**PAE-33639008 – Modification Report for the Bass Point Quarry Modification 3
Hanson Bass Point Quarry (PA 08_0143)**

The EPA has reviewed the modification report and provides comments in Attachment 1.

Figure 3 | Existing and proposed amenity barriers

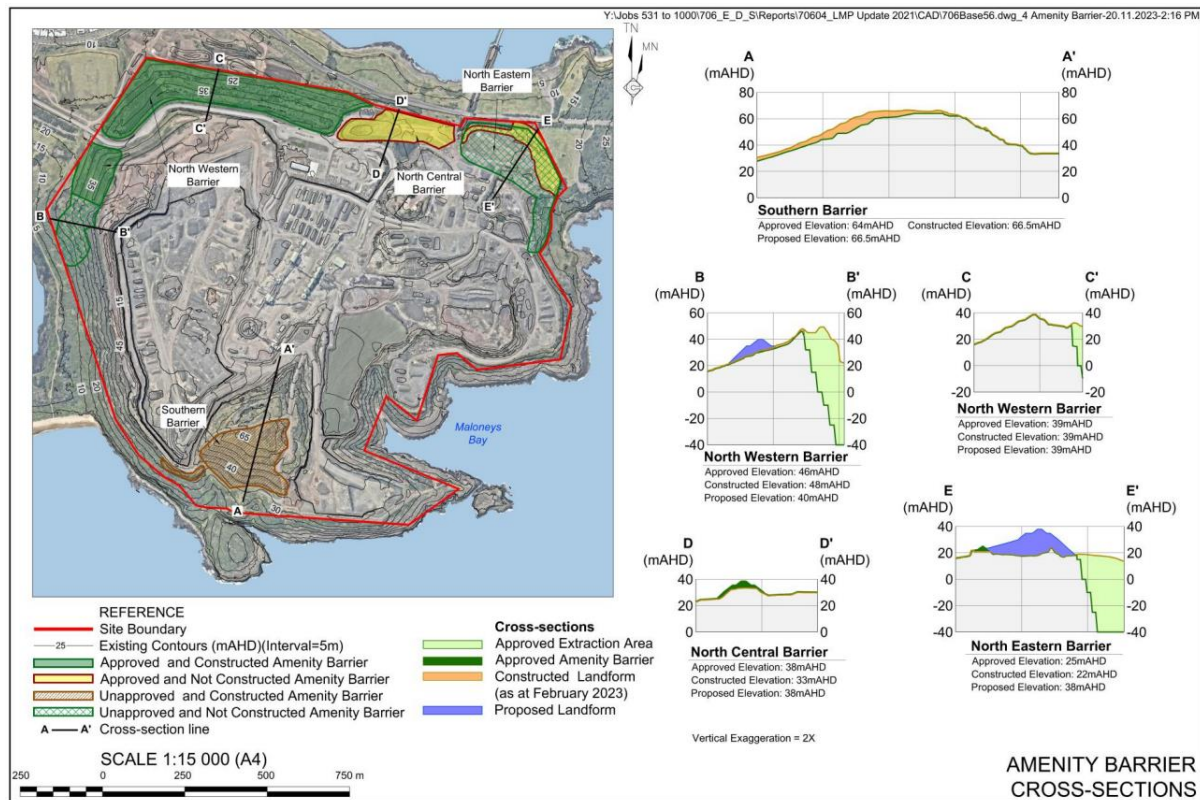
The creation of new amenity barriers has the potential to create additional dust issues during the unloading and landscaping of imported material. Hanson need to ensure all imported material is managed in a way that minimises dust emissions during amenity barrier construction, including but not limited to, dust suppression techniques and limiting construction works to appropriate weather conditions.

The importation of material has the potential to increase truck and machinery movements at the site which may increase the noise generated by the premises. Hanson need to be aware of this risk and only conduct works during approved hours of operation and during appropriate weather conditions.

As noted in the modification report, the local community has raised concerns regarding the proposed amenity barrier, likely due to a lack of information provided by Hanson. Hanson should ensure they provide contemporary information to the local community through the Community Consultative Committee (CCC) in accordance with the Project Approval and at any time a community enquiry is received.

If DPIE approves Modification 3 to the Project Approval, the EPA recommends additional conditions of approval be considered related to:

- Approved limit of material that can be imported per annum.
- Dust management for amenity barrier construction.
- Noise management for amenity barrier construction.
- Ensuring imported material meets VENM and ENM specifications.
